CITY OF ALBUQUERQUE

June 20, 2012

**Re: AMERICA'S PASSTIME, Grading and Drainage Plan
Engineer's Stamp Date 06/11/2012 (C18/D035)**

ORIFICE PLATE/
12" SIDEWALK CULVERT DETAIL

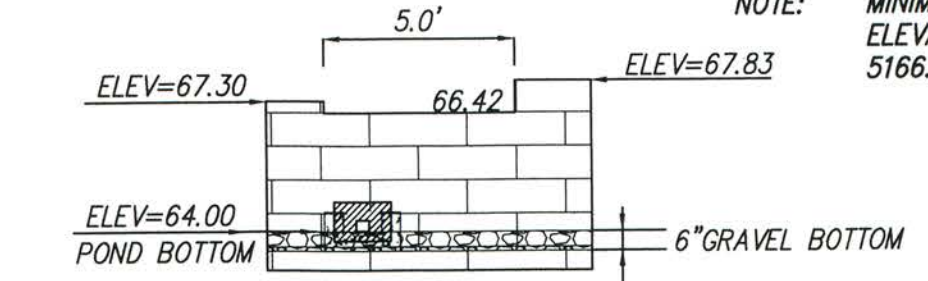
- Sidewalk culvert plate should be extended from the curb to 2' south of the property line. Call out the City of Albuquerque Standard drawing number 2236. Include a note that the contractor will tack weld the bolts on the plate.

EMERGENCY OVERFLOW SPILLWAY

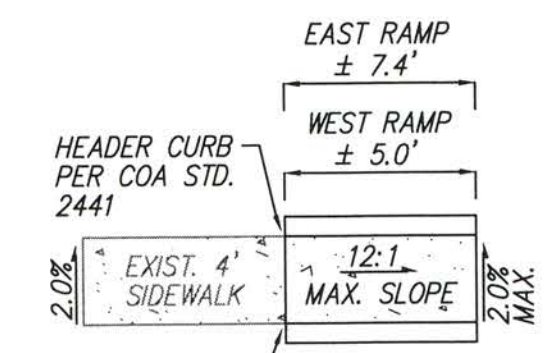
- Provide an emergency overflow and calculations for the pond.
- Please provide slope treatment and a typical section for the areas where the grades exceed 3:1 slope. Please check the grades along the easterly property line.

HANDICAP RAMP DETAIL
DRIVEWAY ENTRANCE

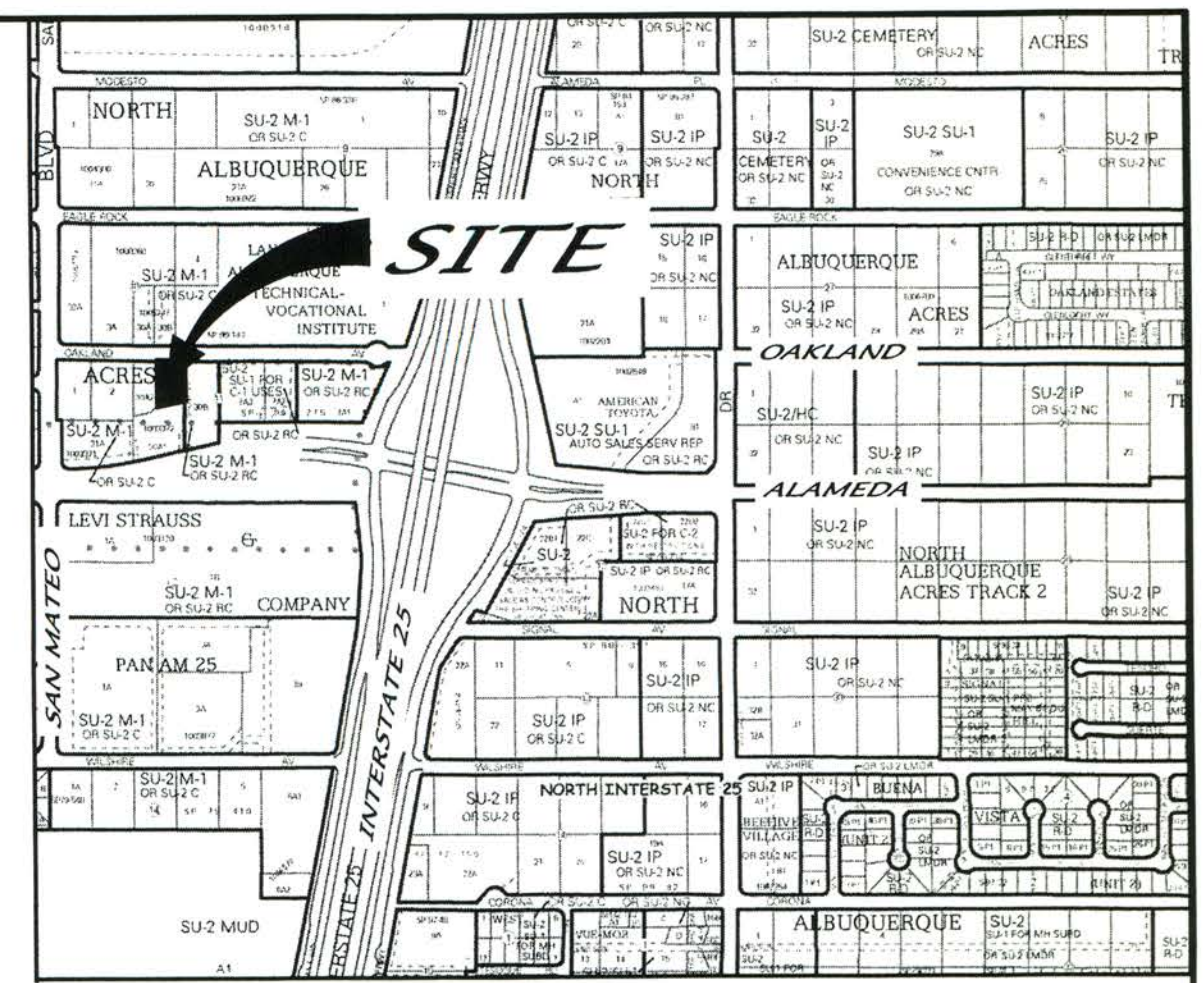
- Show the proposed Handicap Ramp on the plan.
- An invert of the 66.60 is call out on the plan on the northwest corner of the building. How does the runoff enter the pond from this location? Please provide details. Since the WSEL is at 66.70 please make sure that the runoff will not overflow into the adjacent property. The elevations at the property line may have to be at 67.00 or higher.

**AMERICA'S PASTTIME
GRADING & DRAINAGE PLAN**

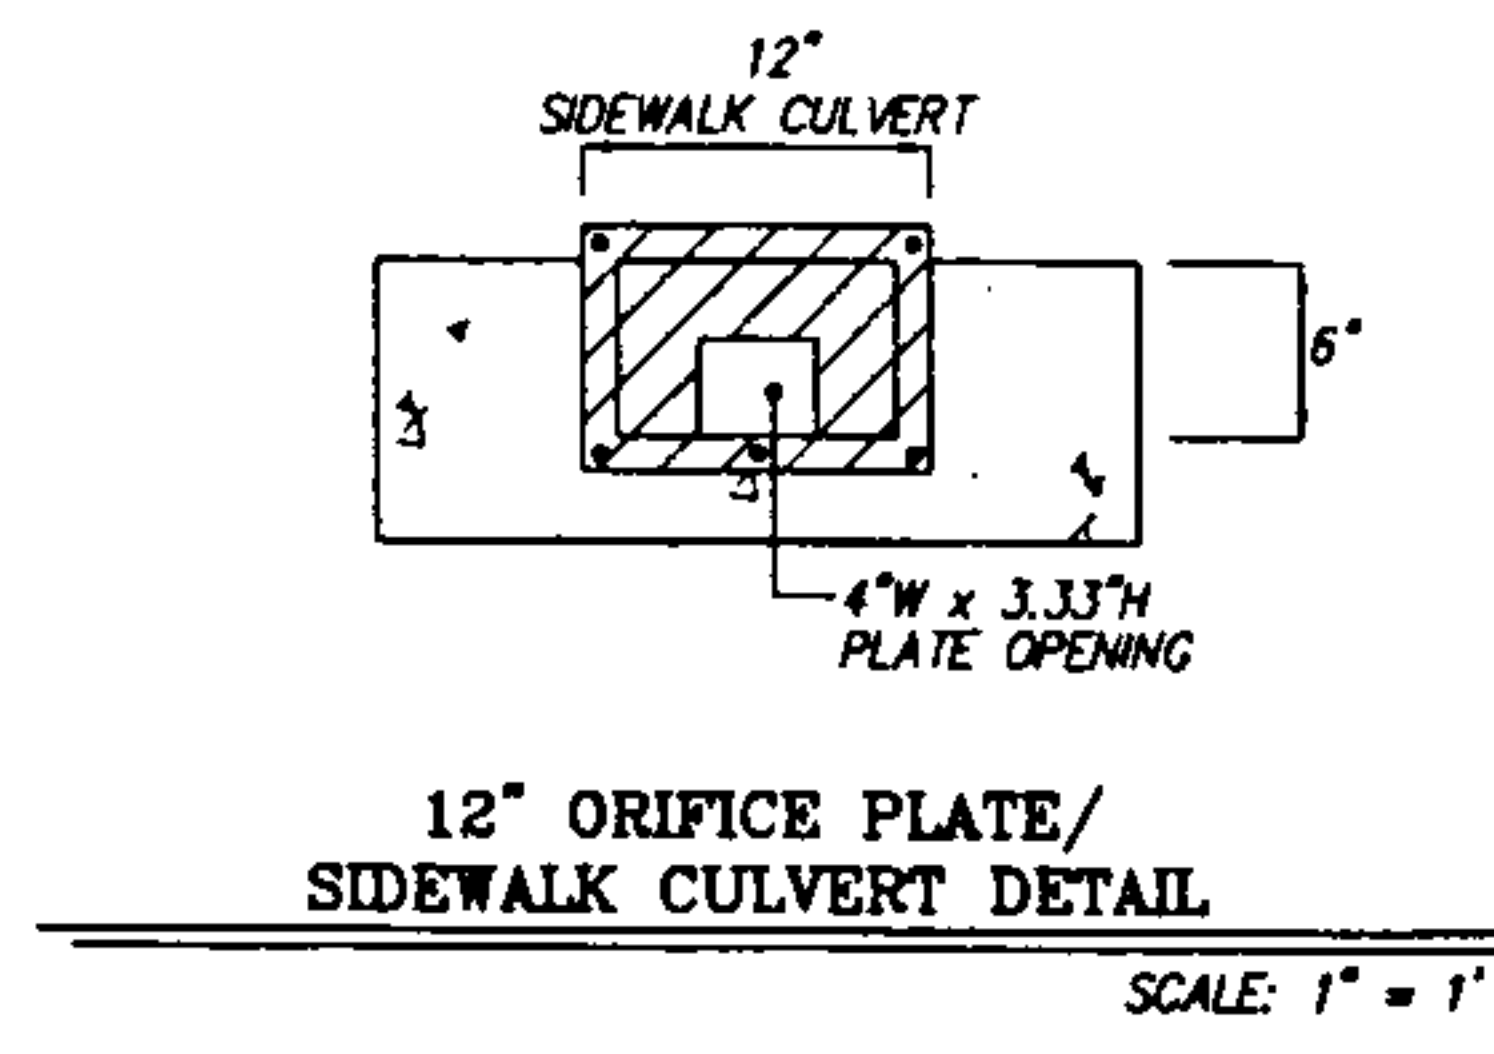
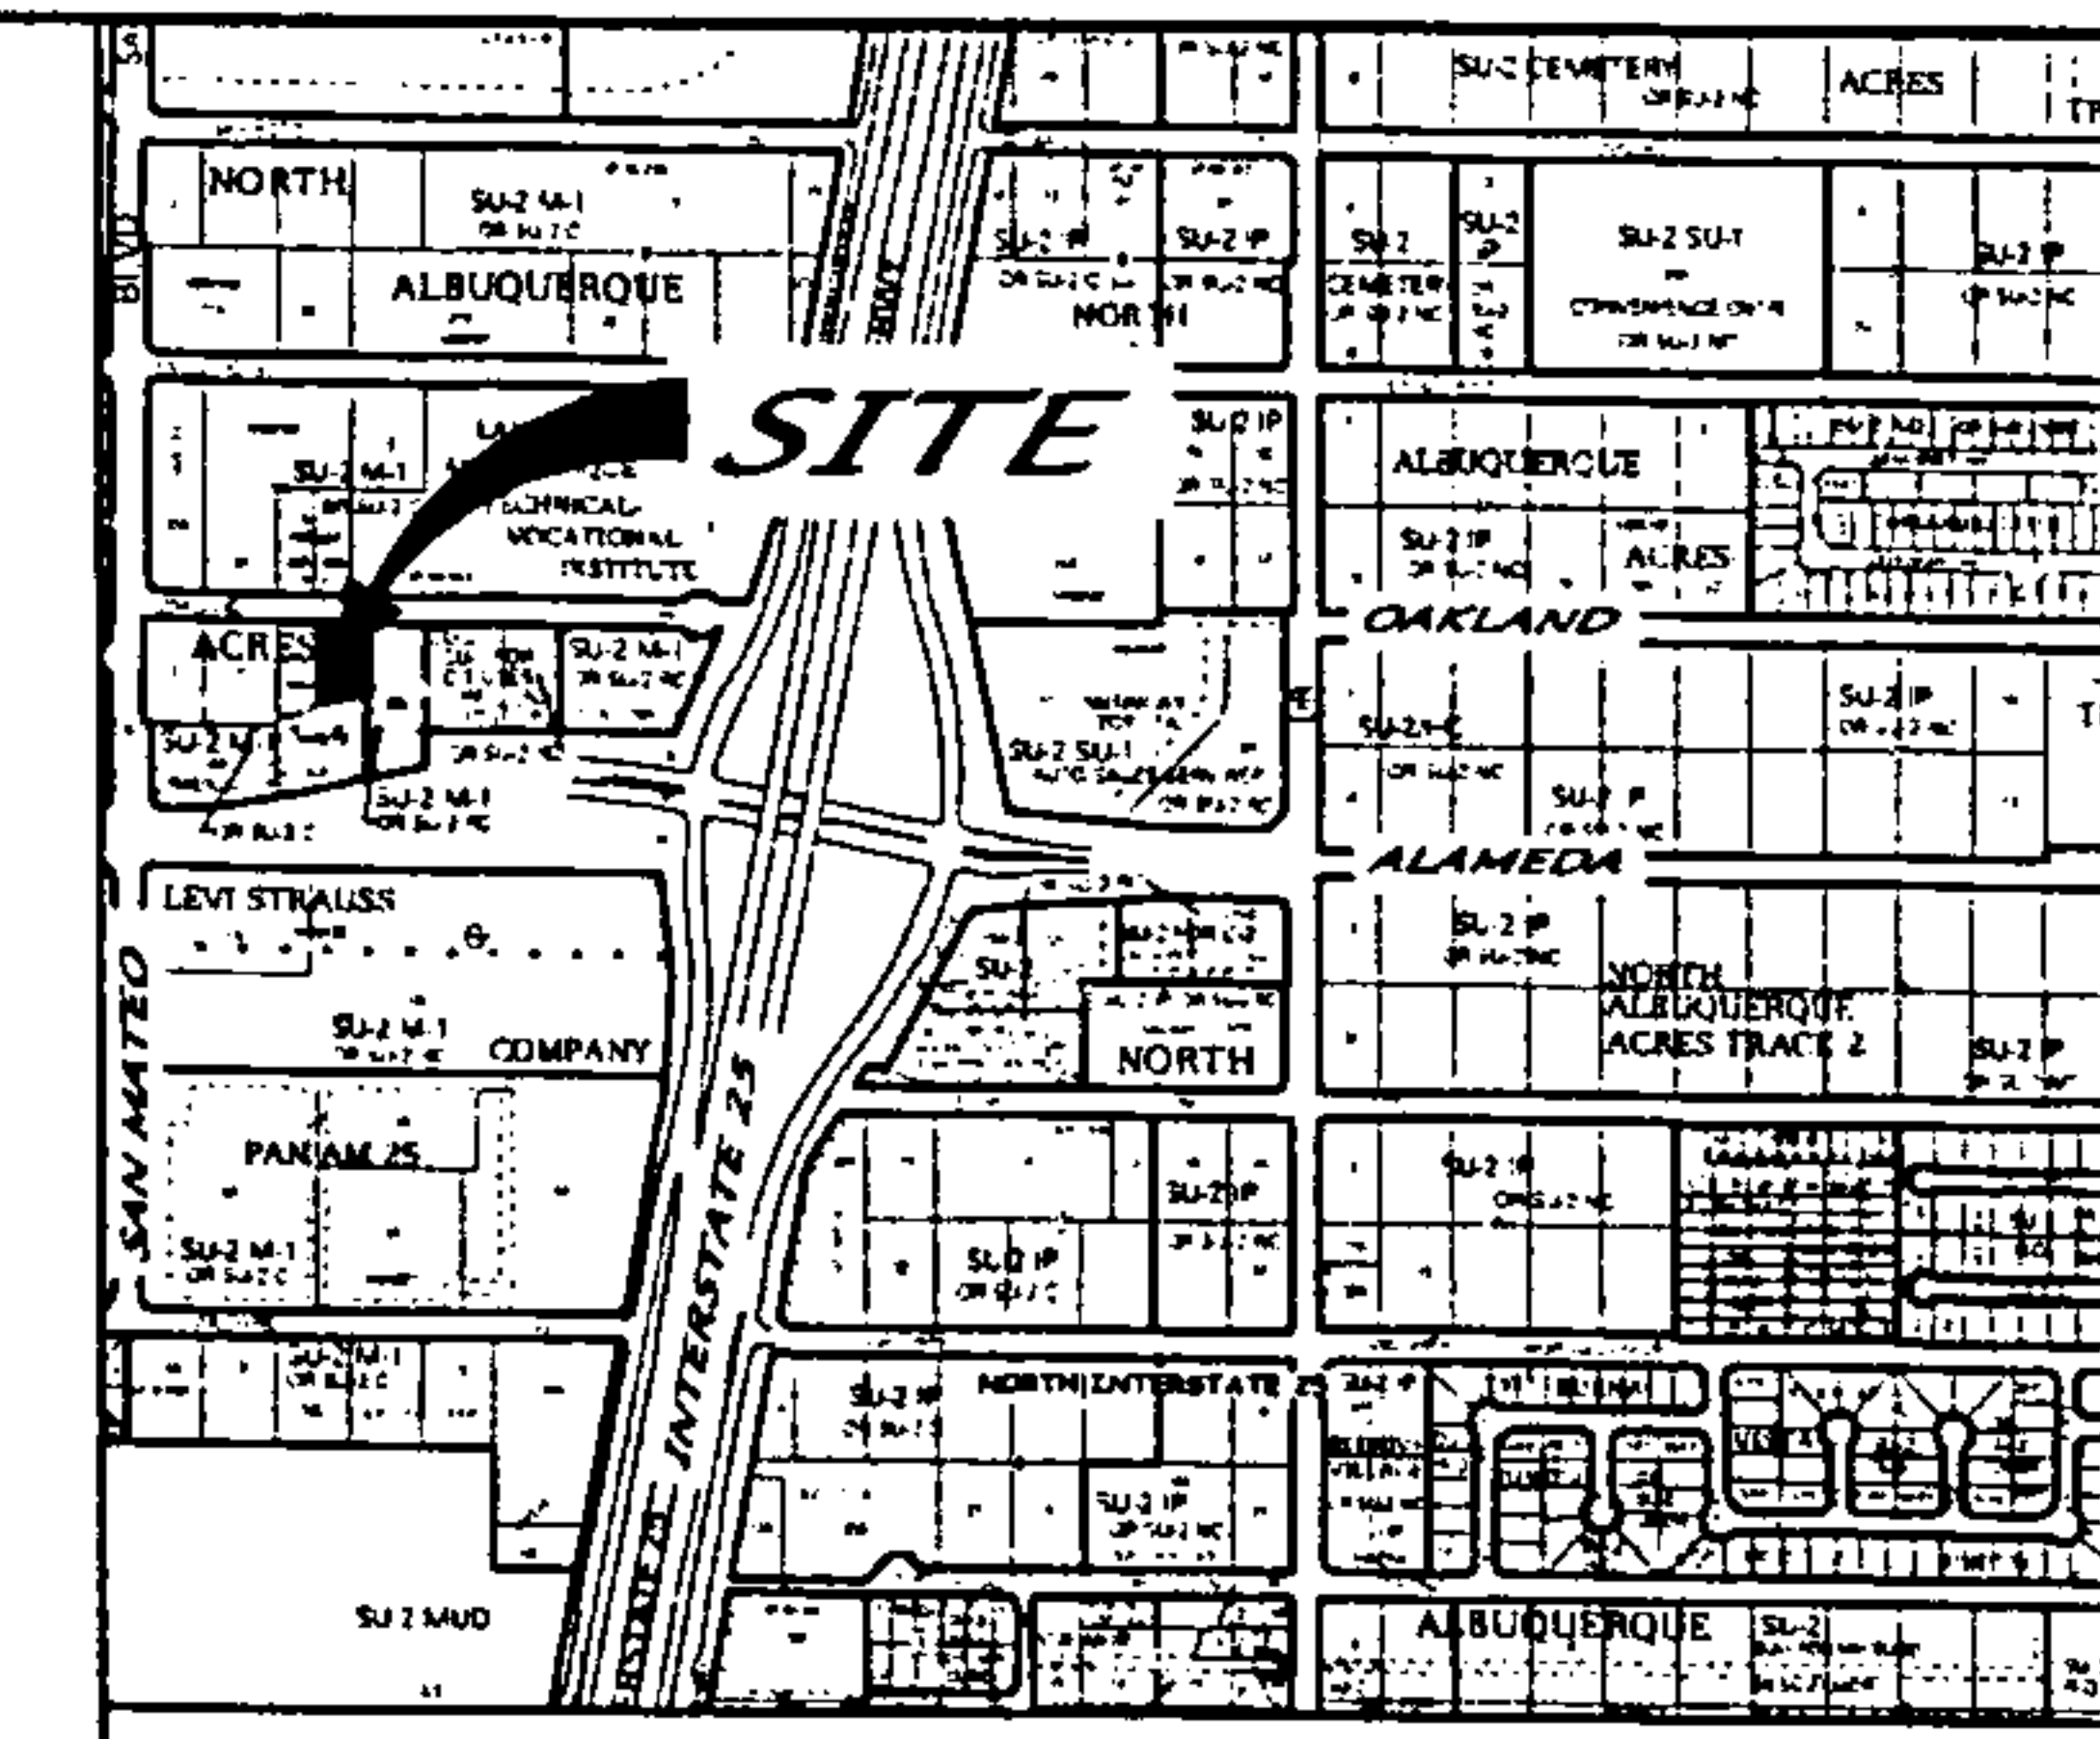
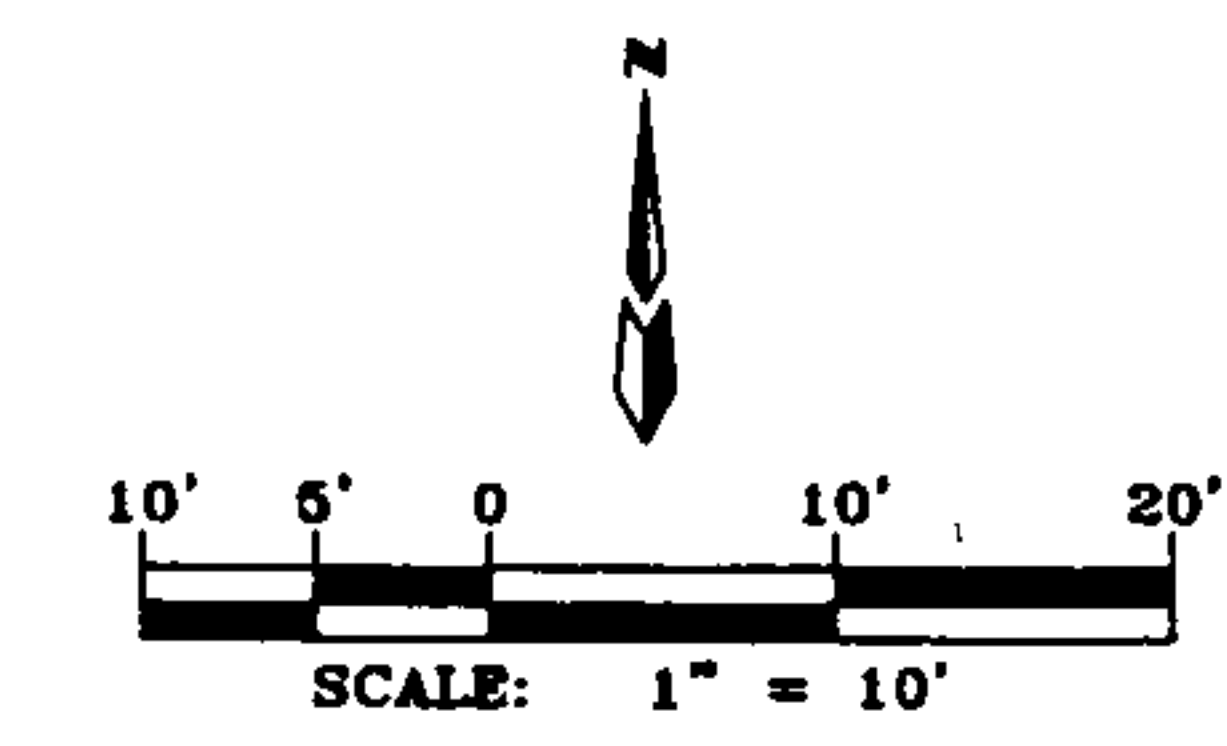
- Include the size for the proposed curb opening at the northwest corner of the northerly parking spaces
- Portion of the proposed detention pond will an approximate 3' cuts into the exiting public utility easement. Can the pond be revised to stay outside the easement?

- Make a definite determination if retaining walls are required.
- Change note number 2 under the "Notice To Contractor" to update #8 .
- Hydrology is requesting that proposed landscape areas be depressed.
